City of Albuquerque

DESIGN HYDROLOGY SECTION
123 Central NW, Albuquerque, NM 87102
(505) 766-7644

February 13, 1985

RE: DOCK & COOLER ADDITION FOR THE BORDEN COMPANY (J-14/D47)

SITE PLAN
 SCALE: 1" = 20'

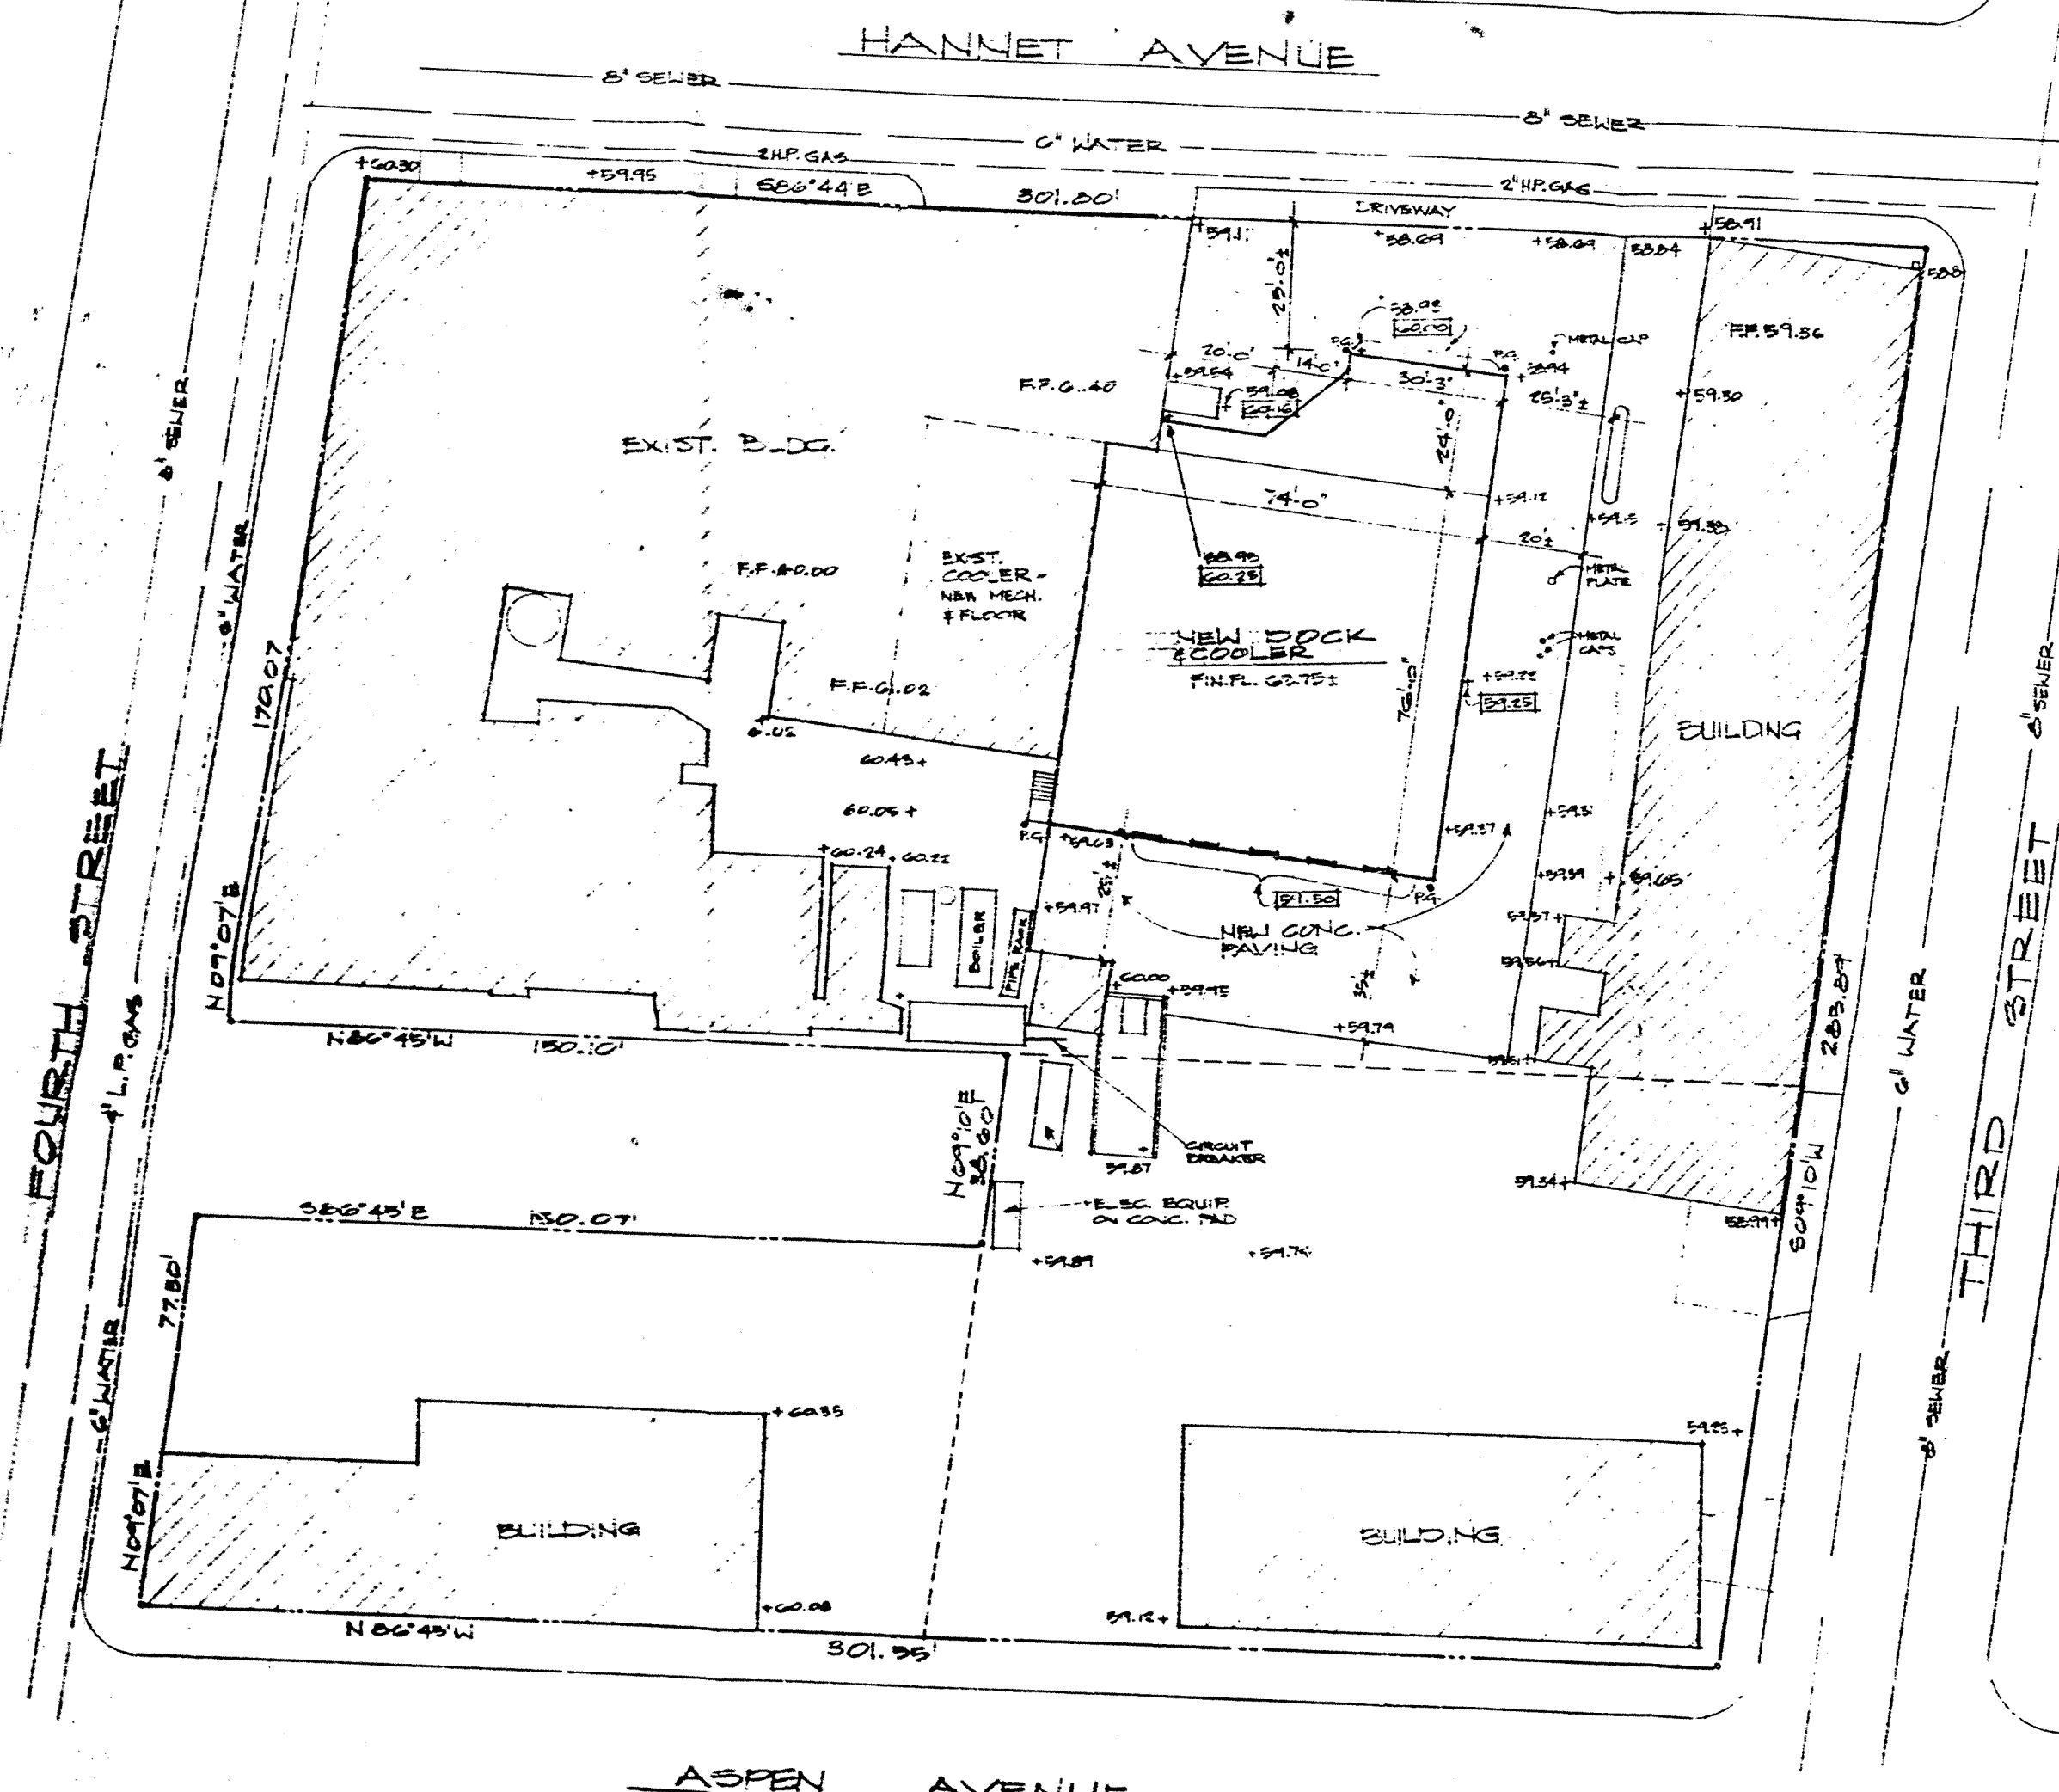
Based on the information provided on your January 28, 1985 submittal, listed are certain items that will need to be addressed before final approval is given:

1. New information sheet with resubmittal designation.
2. Plan must be prepared, stamped, signed and dated by a New Mexico registered engineer.
3. Flow volumes and rates - calculations showing on-site undeveloped and developed flow volumes and rates.
4. Vicinity map showing location of development in relation to well known landmarks, municipal boundaries and zone atlas map index number.
5. Benchmarks - location, description and elevation of the
 - a. Albuquerque Control Survey Vertical Datum
 - b. Temporary benchmark on-site
6. Location and direction of roof drains.
7. Proposed treatment of developed runoff.
8. Top of curb and flow line spot elevations along bordering streets.

9. Legend - See DPM, Vol. 2, tables 27.3a - 27.3d for recommended standard symbols.
